City of Albuquerque Stormwater Construction Site Inspection Report

Project Name:		Valle De Atrisco Apartments					
Location:		10001 Ceja Vista					
Site Contact Name & Agency		Trevor Wismann		ESC File No.		P09E002D	
		Trevco Inc		NPDES Id. No.		NMR1001TV	
Inspection Date:		06/11/19	Start/End Time:	8:55/9:30			
CoA Stormwater Inspector:			Curtis Cherne				
Construction Phase:		vertical					
Type of Inspection:		Regular	Storm Event	Post Storm Event >0.25"	311/Complaint	X	Follow Up

VALLE DE ATRISCO
EROSION & SEDIMENT CONTROL PLAN

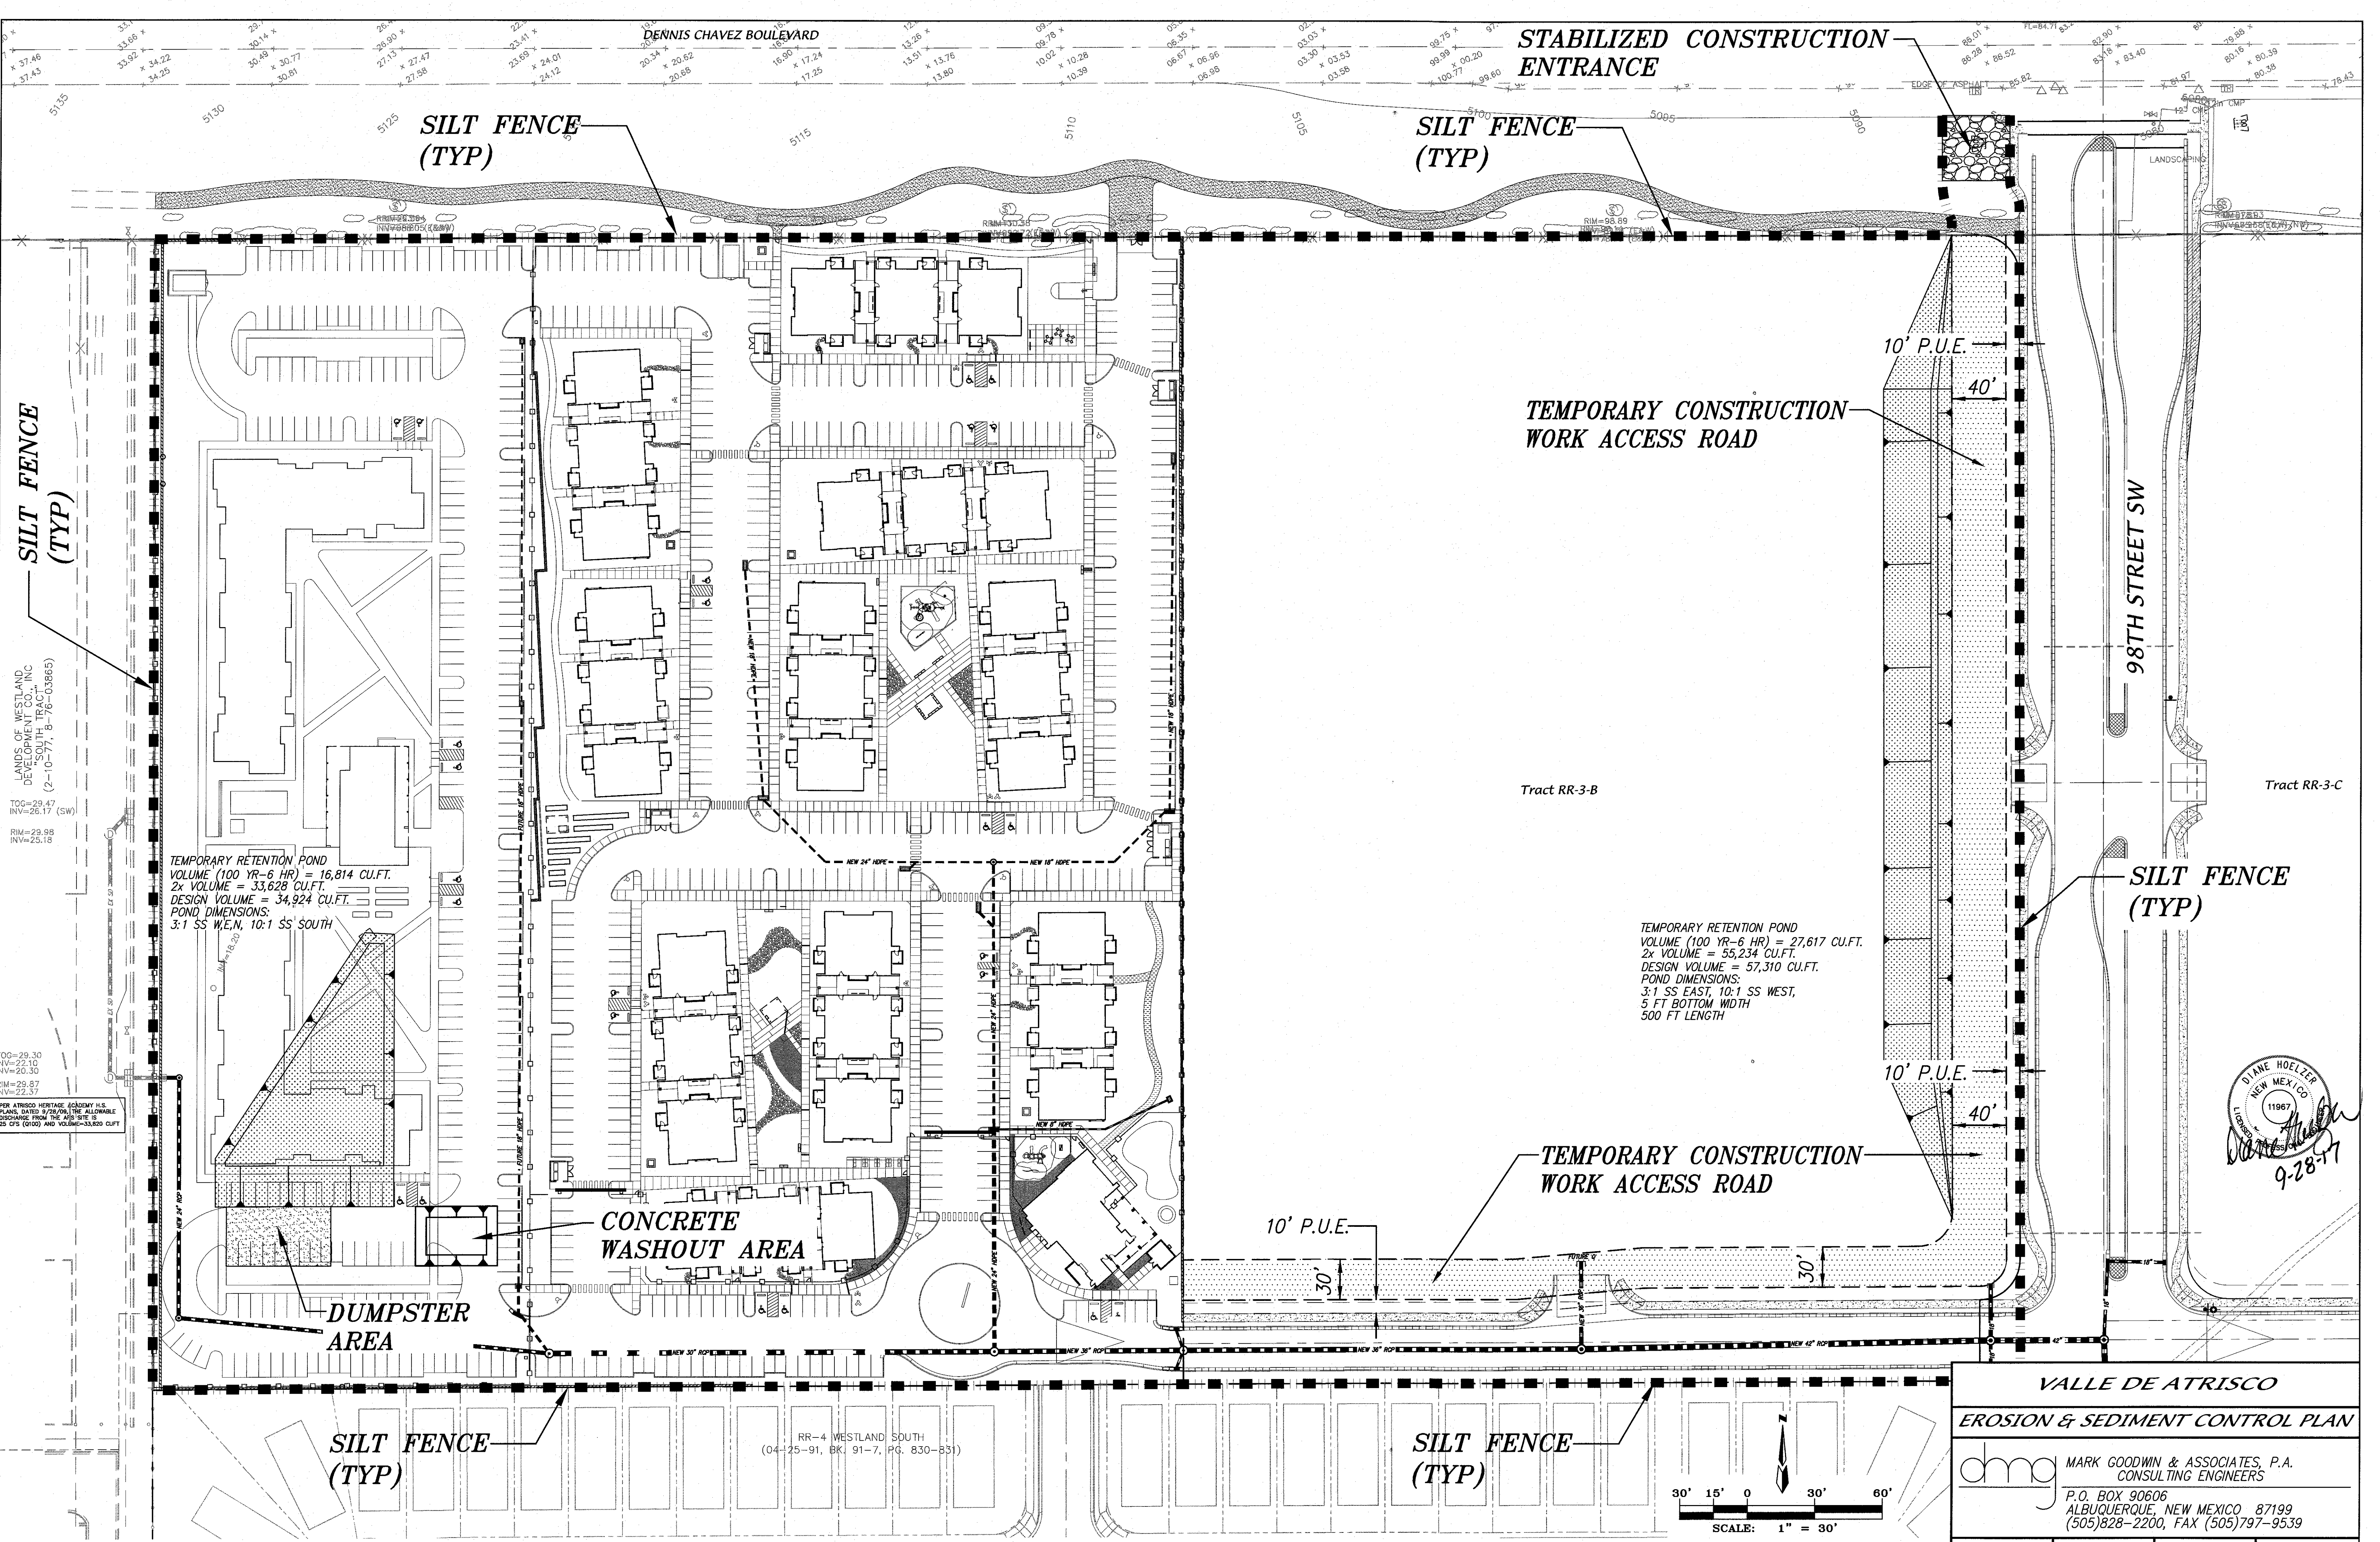
Item Number	Deficiency/ Corrective Action		
1	Silt fence did not extend to north edge of site		
2	construction waste not in an acceptable container NE corner of site		
3	silt fence required maintenance south of entrance		
2.1	Discharge off site? (Y/N)	No	6-6-19
4	Self Inspection Reports		Latest report Date: 3/13/2019

Notes:	
They had installed new silt fence north of entrance, but did not go far enough
